A303 Sparkford to Ilchester Dualling Scheme TR010036

8.6 Draft Statement of Common Ground with Somerset Drainage Board Consortium

STATEMENT OF COMMON GROUND

Version	Date	Status of Version
Rev 0	July 2018	Application Issue
Rev A	January 2019	Submission for Deadline 2

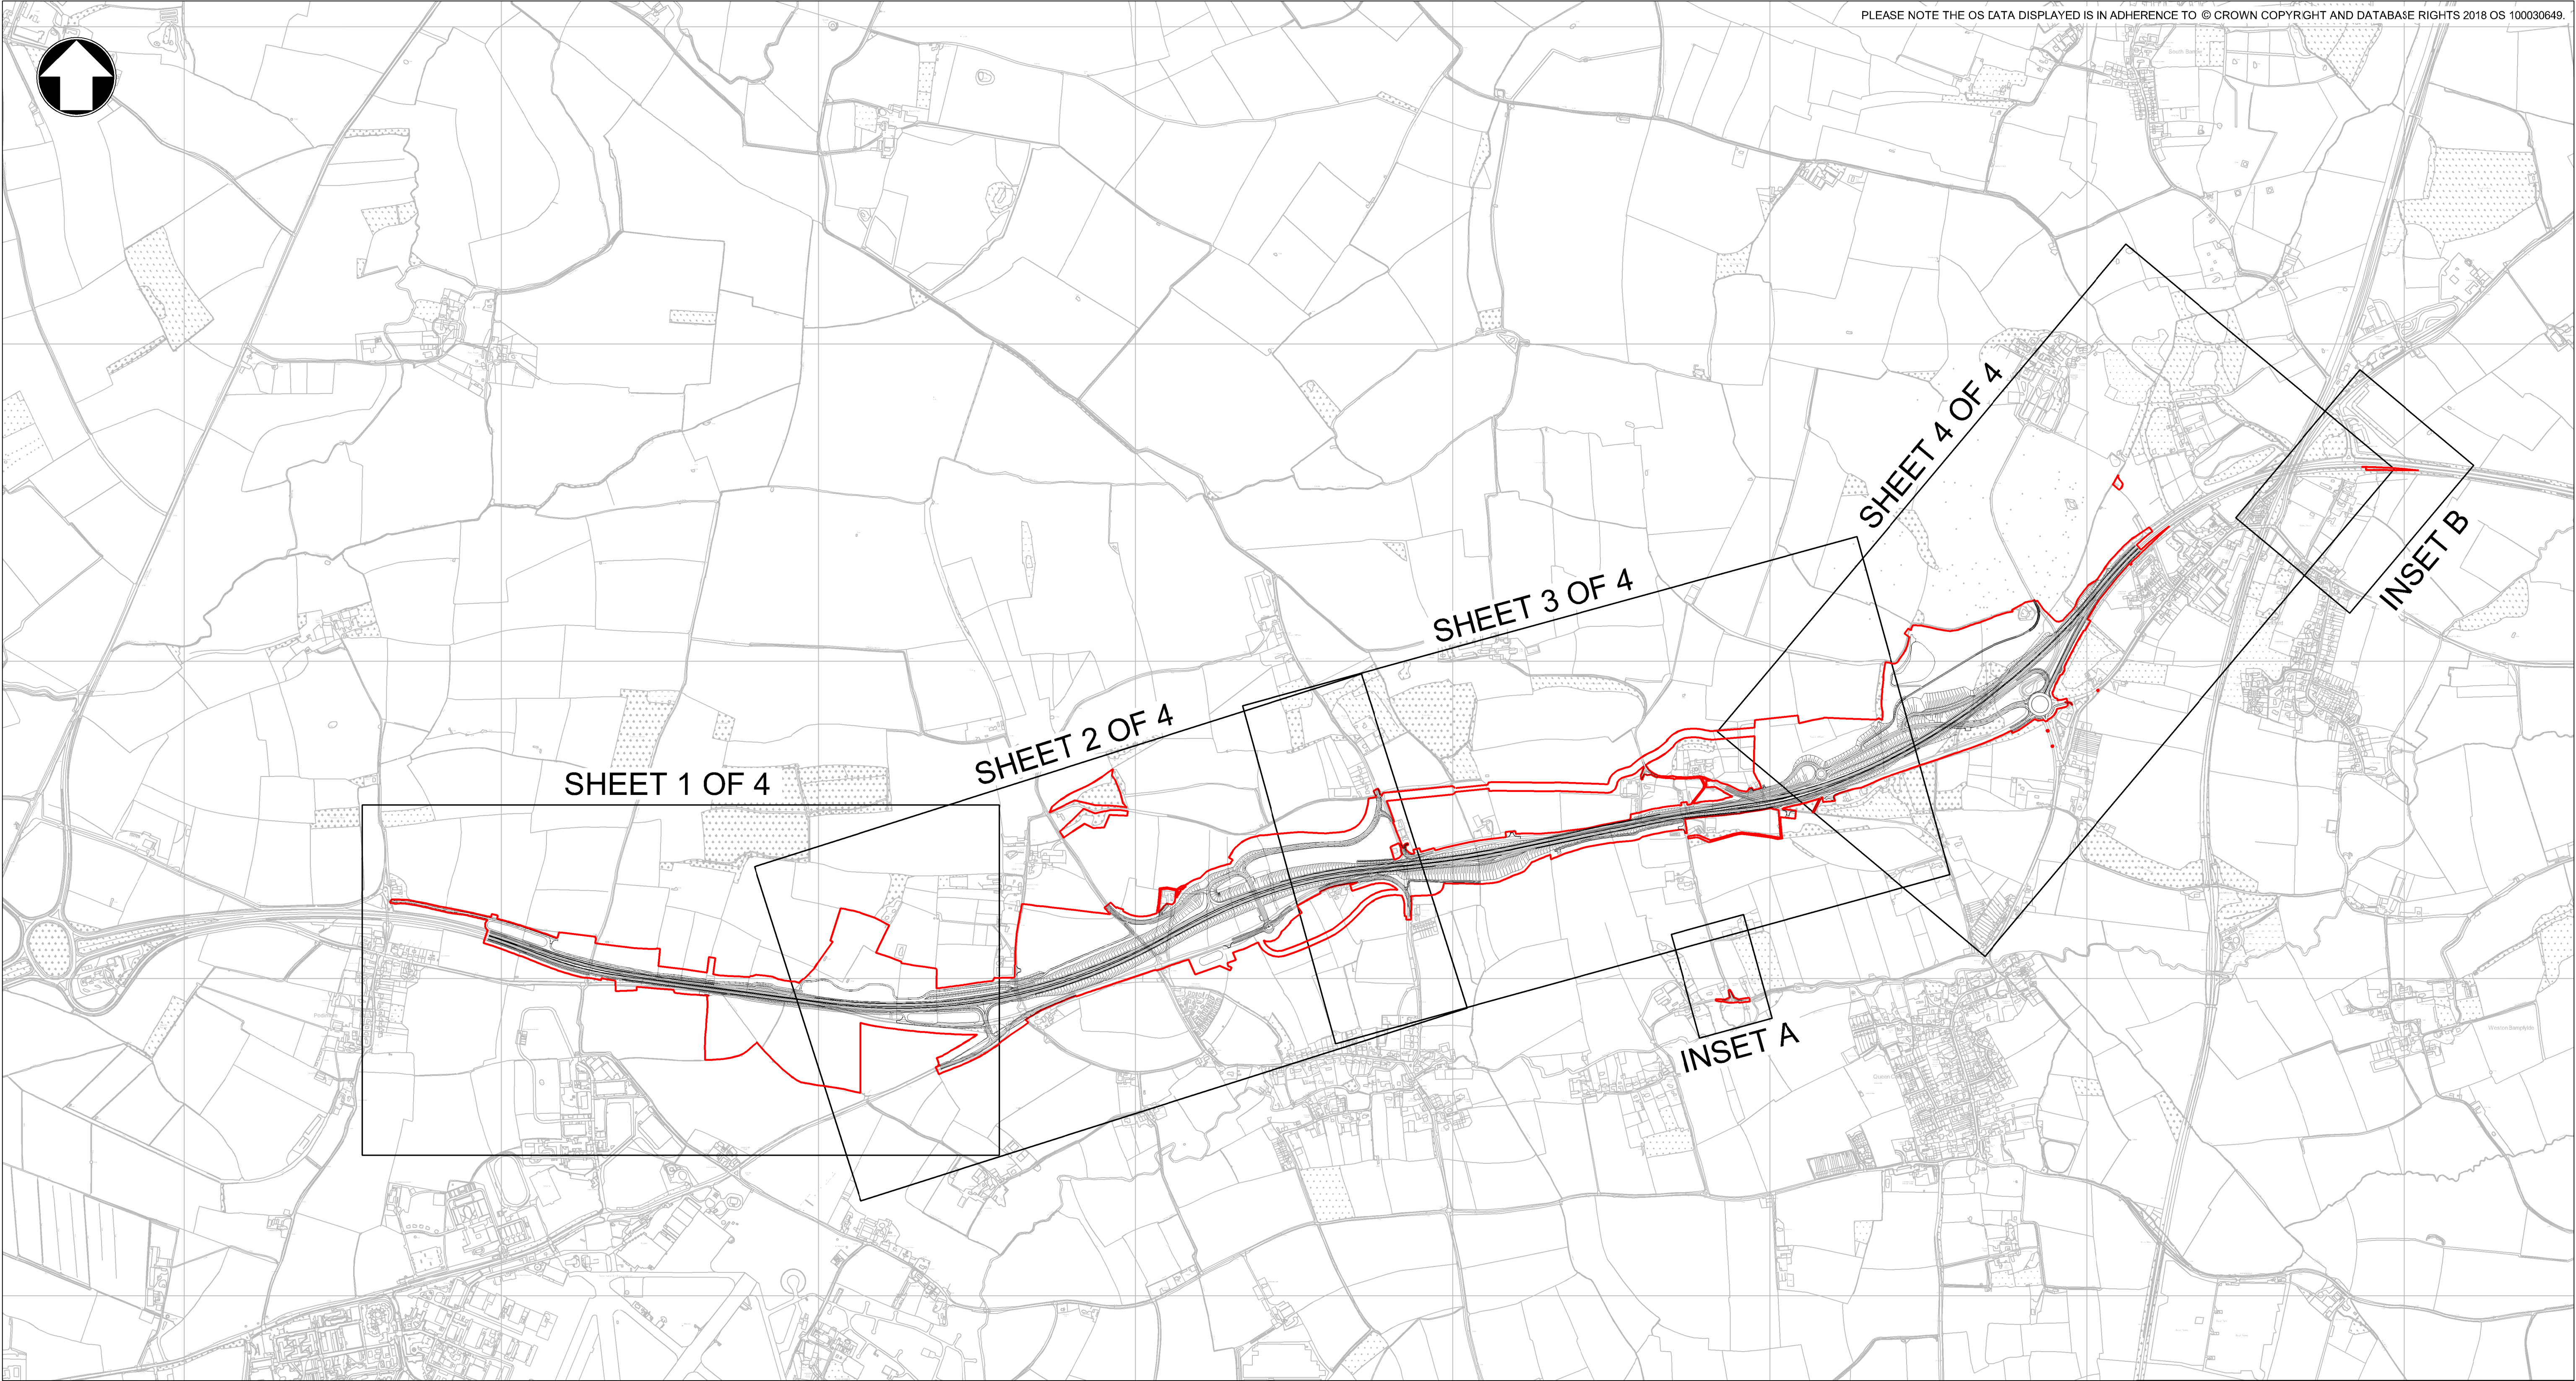
Topic	Stakeholder Comment	Highways England Response	Status
Water quantity	Confirmation is sought that the proposed design will control the overall volume, as well as the overall rate of runoff with sufficient attenuation provided.	Attenuation has been provided, with discharge limited to 1% annual exceedance probability (1 in 100-year event) plus 40% to account for the effects of climate change (Flood risk assessments: climate change allowances, Environment Agency), to no greater than the undeveloped rate of runoff, determined by the calculation of the mean annual peak rate of runoff for a greenfield site (Qbar). Preliminary design discharge rates and volumes shown in Outline Drainage Works Plans (APP-106).	AGREED
Water quality	Confirmation is sought that the proposed pond design provides effective water quality treatment with the use of a permanent water level, and that this volume is sufficient in size. It is recommended that the SuDS Manual (C753) is referred to in the calculation of these permanent volumes, as well as the detailed design of the forebays and vegetation that will be essential for water treatment.	A permanent water level has been provided for each of the proposed ponds. The volume of treatment has been provided in accordance with the SuDS Manual (C753) - '10-15 millimetres of rainfall depth falling over the contributing catchment'. Accepted. Appropriate planting has been considered as part of the landscaping assessment and design. Attenuation feature discharge rates and volumes shown in Outline Drainage Works Plans (APP-106).	AGREED

The use of grassed surface water channels is supported. Confirmation is sought to where they will be located.	Grassed line channels have been incorporated where the carriageway is in cutting. Evidenced in Drainage Strategy Report, included with Environmental Statement Appendix (APP-060). As in accordance with Outline Drainage Works	AGREED

Topic	Stakeholder Comment	Highways England Response	Status
		Plans (APP-106).	
Maintenance and access	<p>There is concern that there is not adequate space provided for adequate and effective maintenance of the ponds and ditches.</p> <p>It is recommended that maintenance tracks are provided, ensuring connectivity to the ponds and ditches.</p> <p>To undertake a full de-silt of the ponds a maintenance strip greater than 4m is required. Further information needs to be supplied on this at the detailed design stage.</p>	<p>A grassed 4 metre maintenance strip has been provided around each pond and along each ditch. Additional access tracks have been provided to provide access to the ponds.</p> <p>As in accordance with Outline Drainage Works Plans (APP-106).</p>	NOT AGREED
	<p>There is concern that the maintenance tracks do not provide access to the control structures, which would need to be maintained and accessed in the event of a large pollution incident.</p>	<p>Accepted.</p> <p>The ponds and maintenance tracks have been redesigned to provide access to these structures.</p> <p>Access shown in Outline Drainage Works Plans (APP-106).</p>	AGREED
